SITE DEVELOPMENT PLAN FOR WALDEN SANITATION DISTRICT WASTEWATER TREATMENT PLANT PROJECT EL PASO COUNTY, COLORADO MARCH 2026

V3_ Site Dev Plan.pdf Markup Summary

EPC Stormwater- Zachary (3)

SHEET TITLE: SITE DEVELOPMENT PLAN		
PROJECT NUMBER: PCD FILE PPR2538	SCALE: 1" = 80'	SHEET: C1.2

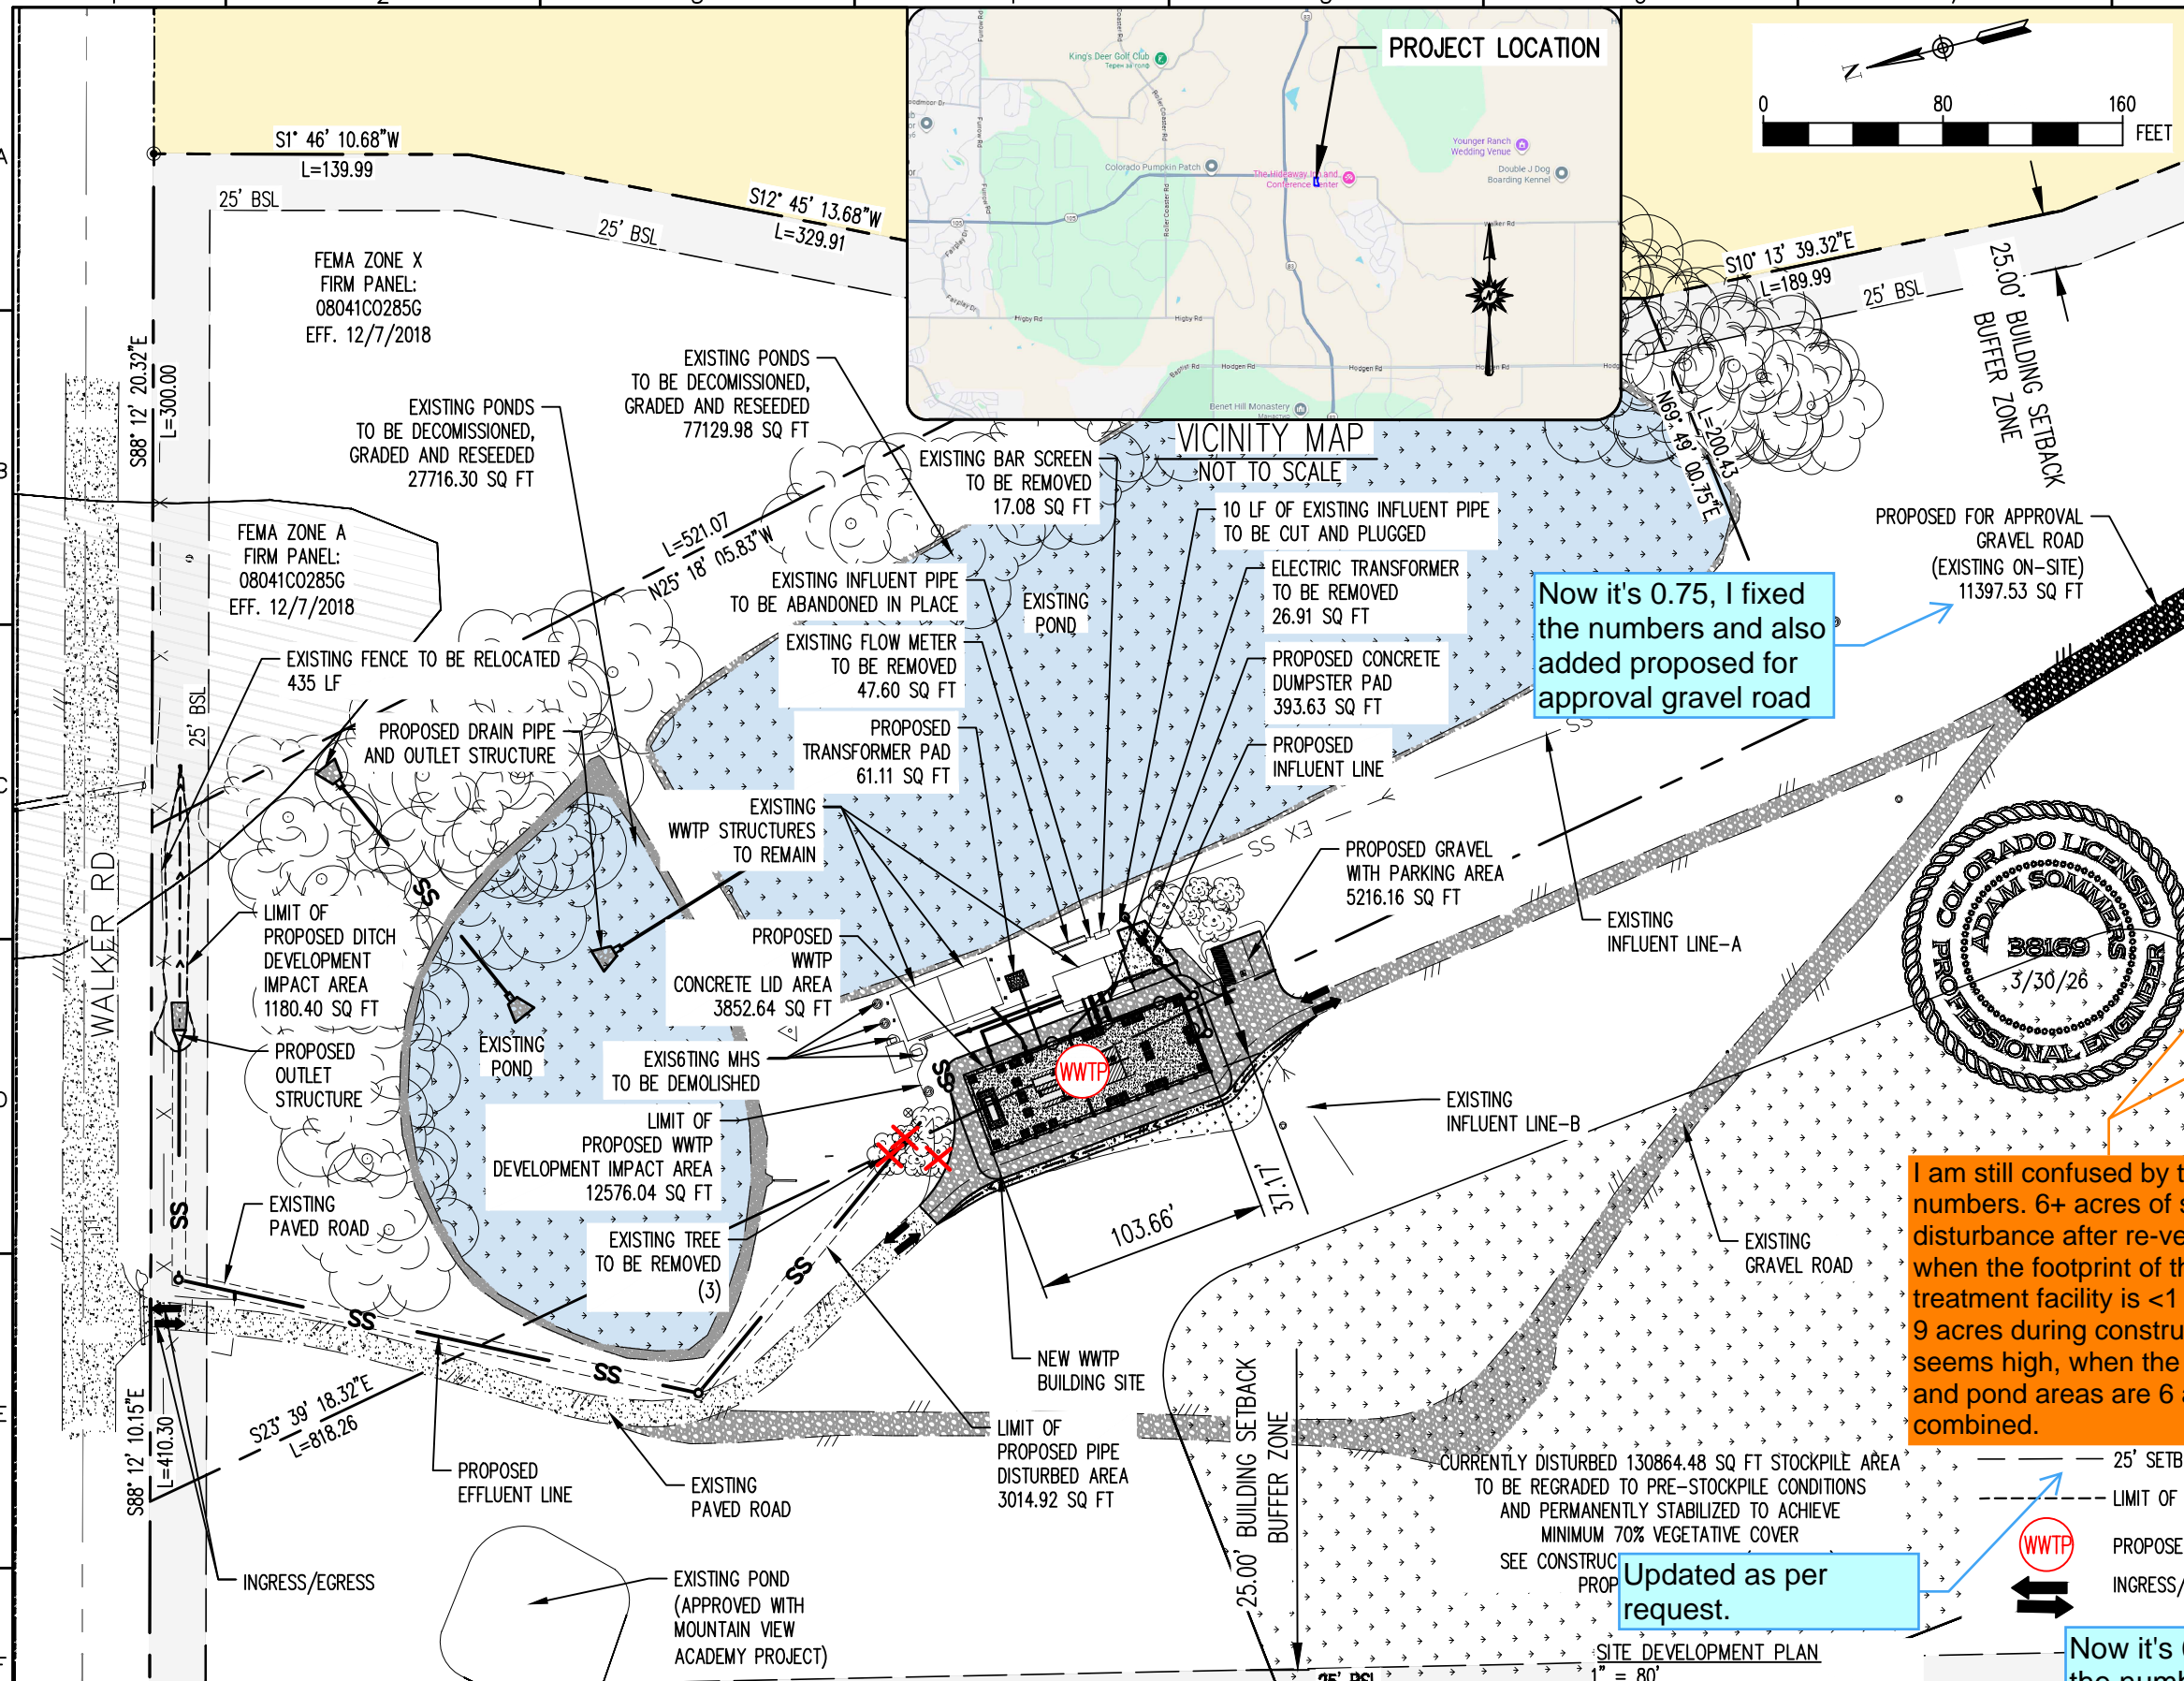
Areas do not match.

I am still confused by these numbers. 6+ acres of soil disturbance after re-vegetation when the footprint of the new treatment facility is <1 acre. And 9 acres during construction seems high, when the stockpile and pond areas are 6 acres combined.

0.54 ac per previous sheet?
